Marge Schmuckal - Re: Gulliver - Peaks Island

Thank you Brenda,
Your outline of our meeting and conversation is accurate. I do agree that a 5' strip of land down to Island Avenue would afford the lot with the existing single family to meet the minimum street requirement of the IR-2 Zone. therefore, the proposed division of land would be allowed as discussed.
Marge Schmuckal
Zoning Administrator

I am writing to follow up on our meeting this morning during which we discussed what I have termed "Option C" for division of the Gulliver Property on Peaks Island (87-K-2, 87-K-8 and 87-K-29).

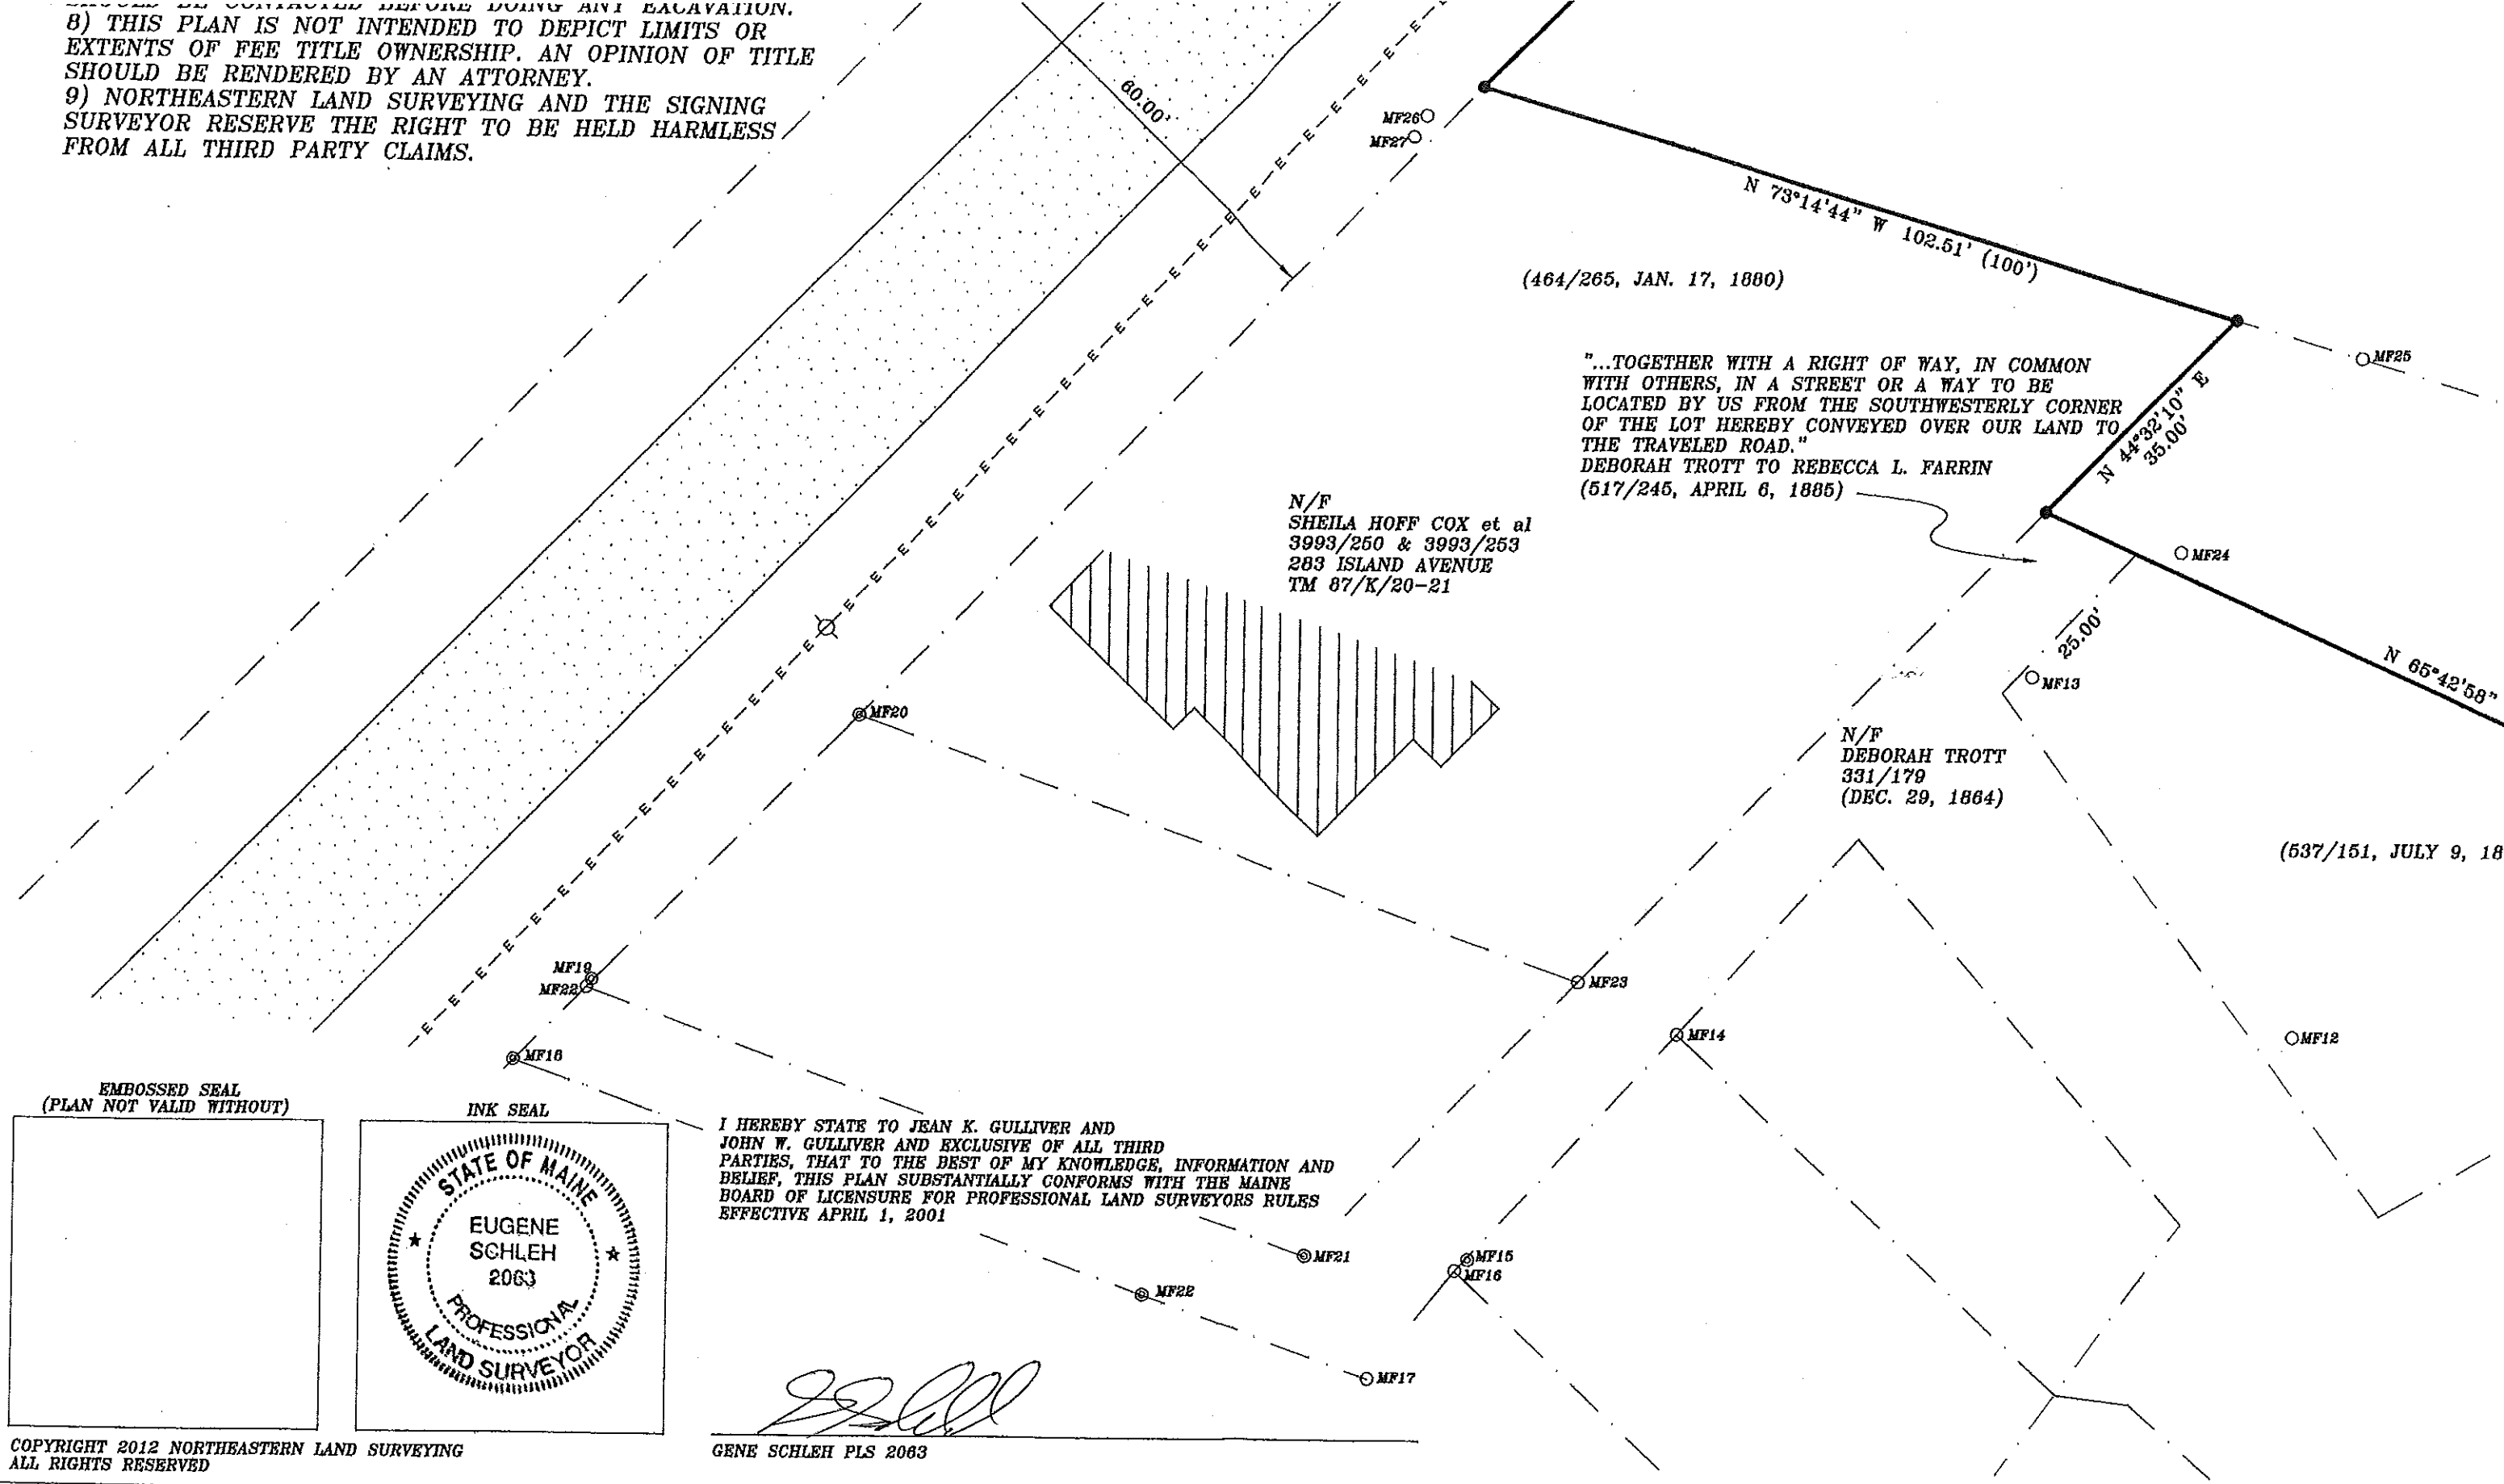
I am in receipt of your option "C". Sending plans in an e-mail are really impossible to for me to read. I can enlarge, but I can not read it because of graininess. However, the concept could work. Both lots need to have 70' street frontage. So I am doing a lot of assumptions.

As I understand your letter, the only legal flaw in the configuration I labeled as Option A is that it yielded total frontage of only 68.93', when the minimum is 70.

I have attached an Option C to this email, which would add a much narrower "tail" down to Island Avenue than Option B. This cures the problem you identified in your February 20 letter, I believe. It would provide total frontage for Lot 1 of at least 70', while allowing the Gullivers to divide the parcel in the way that seems more natural given the lay of the land.

Using the full-size plan, it was easier to illustrate the division line my clients propose, which is an angular division of the portion of the parcel that fronts on Island Avenue, with a narrow strip of what will be Lot 1 extending down to Island Avenue to provide bring the frontage total into compliance with the zoning requirements.

As we discussed, the Pleasant Avenue frontage is 68.93 feet, and the minimum required frontage is 70 feet. While technically only 1.07 feet of frontage is required to meet the zoning requirements, you have asked that the strip of Lot 1 that will extend to Island Avenue be five (5) feet wide to make it useful (i.e., so the owners of Lot 1 would be able to walk along the edge of Lot 2 to get to Island Avenue).

My clients are comfortable with that 5-foot-wide requirement. Their surveyor, Gene Schleh of Northeastern Land Surveying, will be calculating and drawing a division line soon that will make each lot at least 20,000 sf. I will provide you with a copy of that drawing for the file, so there will be an understanding of the history of this when a building permit is sought for the new house to be built on Lot 2.
